An
Bord
Pleanála

Inspector's Report ABP-309975-21

Whether the construction of an extension to the rear of existing dwelling house, including minor works and repairs to the existing dwelling house at No 6 Palace Road, Elphin, Co Roscommon, is or is not development and is or is not exempted development.

No 6 Palace Road, Elphin, Co Roscommon.

**DRAWING TITLE** Floor plans

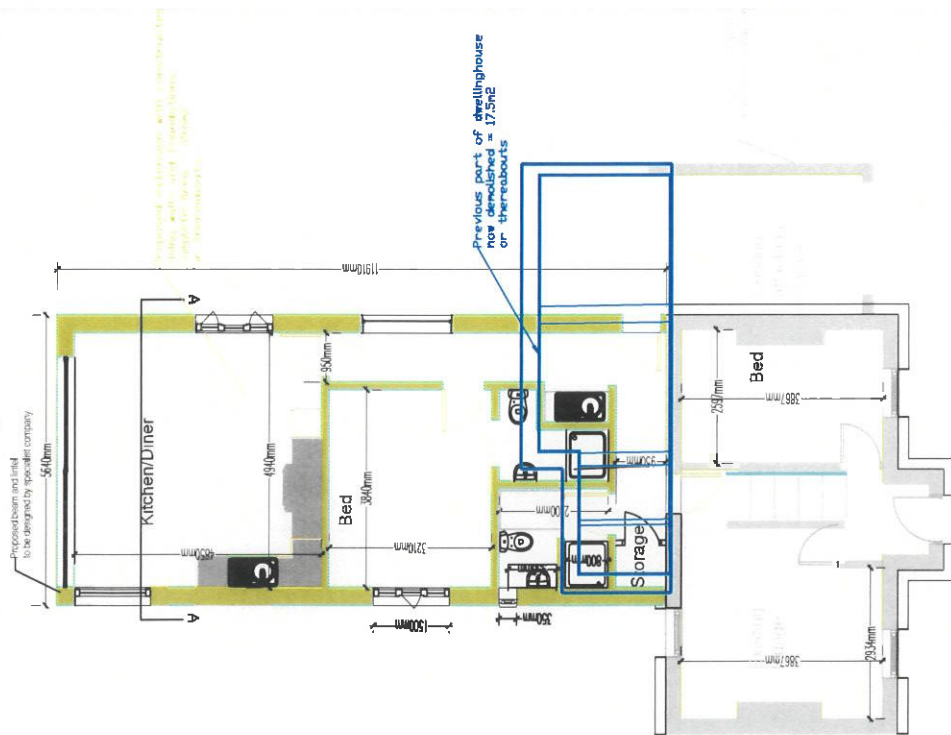
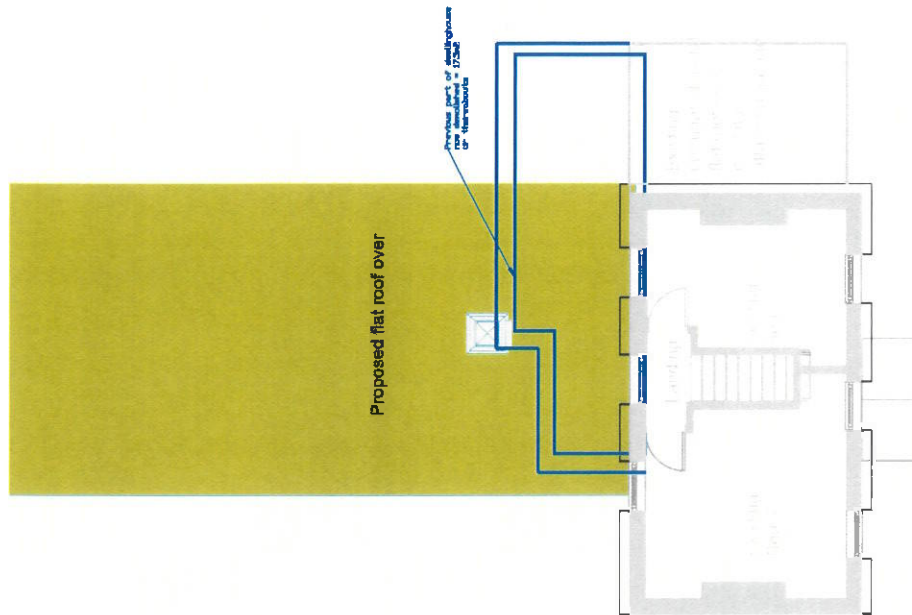
- 8.1.2. I note that the external measurements of the subject extension as set out in submitted drawings is 5.64m x 11.91m. The referrer indicates a net floor area of the extension of 571m². The ridge height of the extension is 3.376m. The proposed structure is 2.5m and 2m from the boundaries with the adjoining properties to the north and south respectively. Minor works and repair to the existing dwellinghouse are proposed though specifics of same are not detailed.

As the new extension proposed is 57.1m² this is in excess of the permitted exemption threshold of 40m² therefore is not exempted development.
